CITY OF ALBUQUERQUE

June 22, 2021

Re: San Jacinto Ave NE
12710 San Jacinto Ave NE
Traffic Circulation Layout
Architect's Stamp 06-17-2021 (K22-D063)

Based upon the information provided in your submittal received 06-22-2021, the above referenced plan cannot be approved for Building Permit until the following comments are addressed:

Date: April 19, 2022  
Sheet: Site Plan

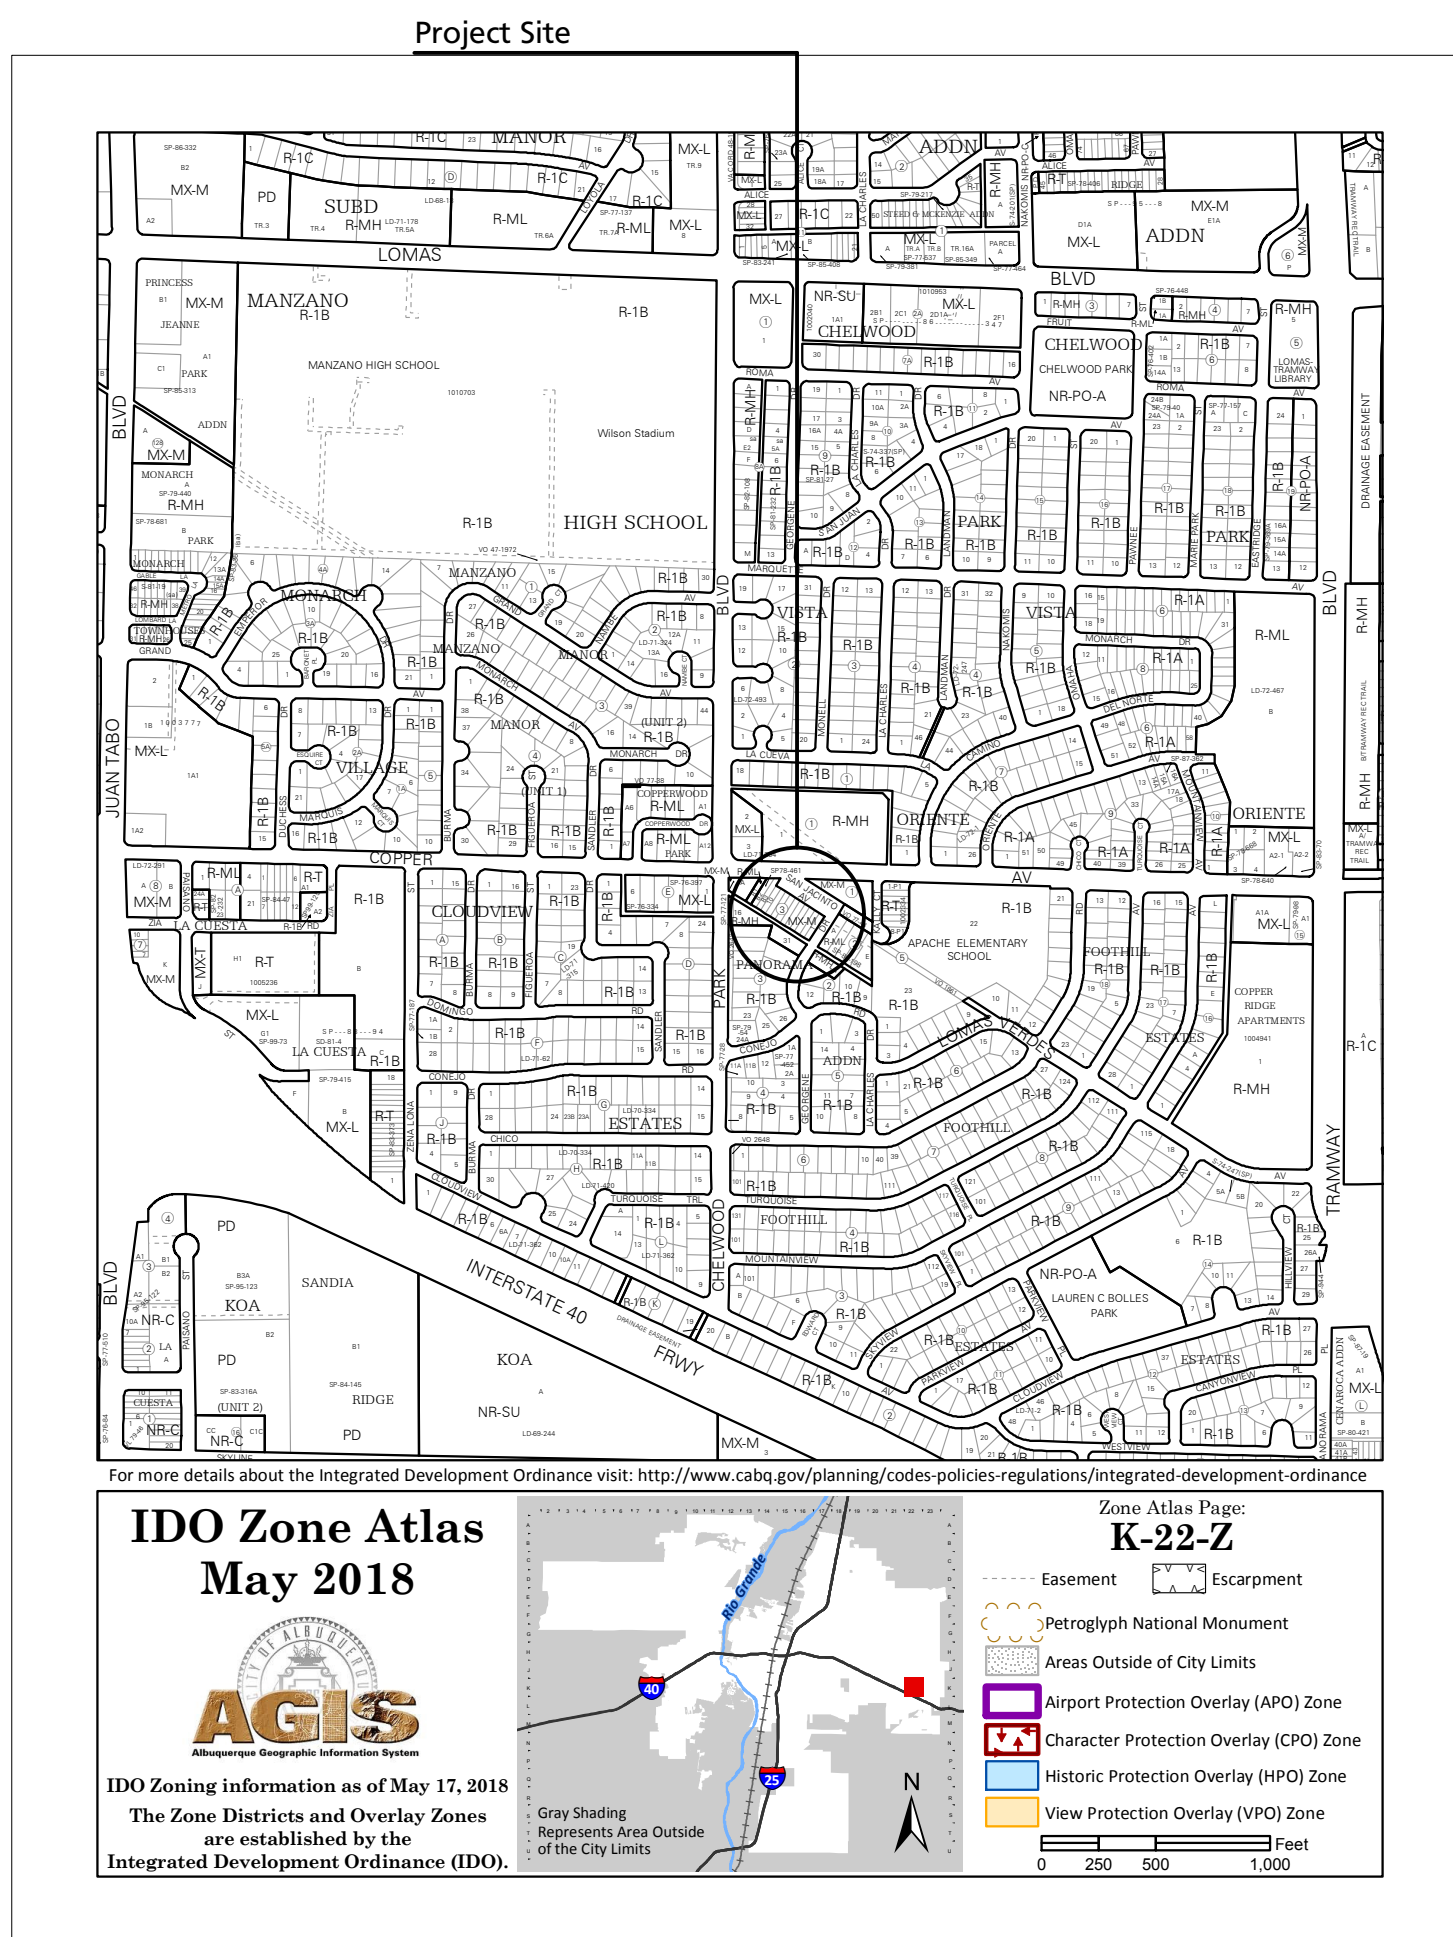
1. Listed is the number of parking spaces required by the IDO as well as the proposed number of parking spaces including bicycle and motorcycle parking. **Discuss with Zoning because the status for ADA parking space, motorcycle and bicycle are missing from your calculations.**

2. **Site Plan: need to show the property lines of the site and the adjacent properties.**
3. San Jacinto Ave driving surface appears to be temporary asphalt so a work order might be required to provide a permanent asphalt section on this roadway. Please verify the surface condition thru as-builts.

4. **Clarify the extents of the current phase. Provide a phasing plan.**
5. Identify all existing access easements and rights of way width dimensions.
6. Identify the right of way width, medians, curb cuts, and street widths on Copper and San Jacinto Ave.

7. Clarify existing property lines and proposed property lines. It is not clear on the site plan.
8. Driveway off San Jacinto: The proposed driveway needs to be ADA accessible. Provide construction notes to define this ADA requirement. The location of the driveway will need to be 75 ft from Copper's face of curb/flowline. Copper is classified as Major Local street and will need to follow design criteria for driveway location.

9. Provide construction notes for new sidewalk, curb and gutter and notes for all existing infrastructure fronting Copper and San Jacinto.
10. Please list the widths for all existing and proposed parking spaces. Some dimensions are not shown.

12. Label the compact parking spaces by placing the words "**COMPACT**" on the pavement of each space.
13. The ADA accessible spaces must include an access aisle. Van accessible aisles should be 8ft wide; all others should be 5ft wide.

14. The ADA accessible parking sign must have the required language per 66-7-352.4C NMSA 1978 "**Violators Are Subject to a Fine and/or Towing.**" Please call out detail and location of signs.

16. ADA curb ramp will need to be provided at the corner of Copper and San Jacinto and the ramp must be updated to current standards and have truncated domes installed.

22. Show all drive aisle widths and radii. Some dimensions are not shown.
23. List radii for all curves shown; for passenger vehicles. Radius for delivery trucks, **fire trucks, etc. is 25 ft. or larger.**

25. Per the IDO, **a 6 ft. wide ADA accessible pedestrian pathway is required from the public sidewalk to the building entrances.** Please clearly show this pathway and provide details.

32. Please provide a sight distance exhibit
33. Show the clear sight triangle and add the following note to the plan: "Landscaping and signage will not interfere with clear sight requirements. Therefore, signs, walls, trees, and shrubbery between 3 and 8 feet tall (as measured from the gutter pan) will not be acceptable in the clear sight triangle.
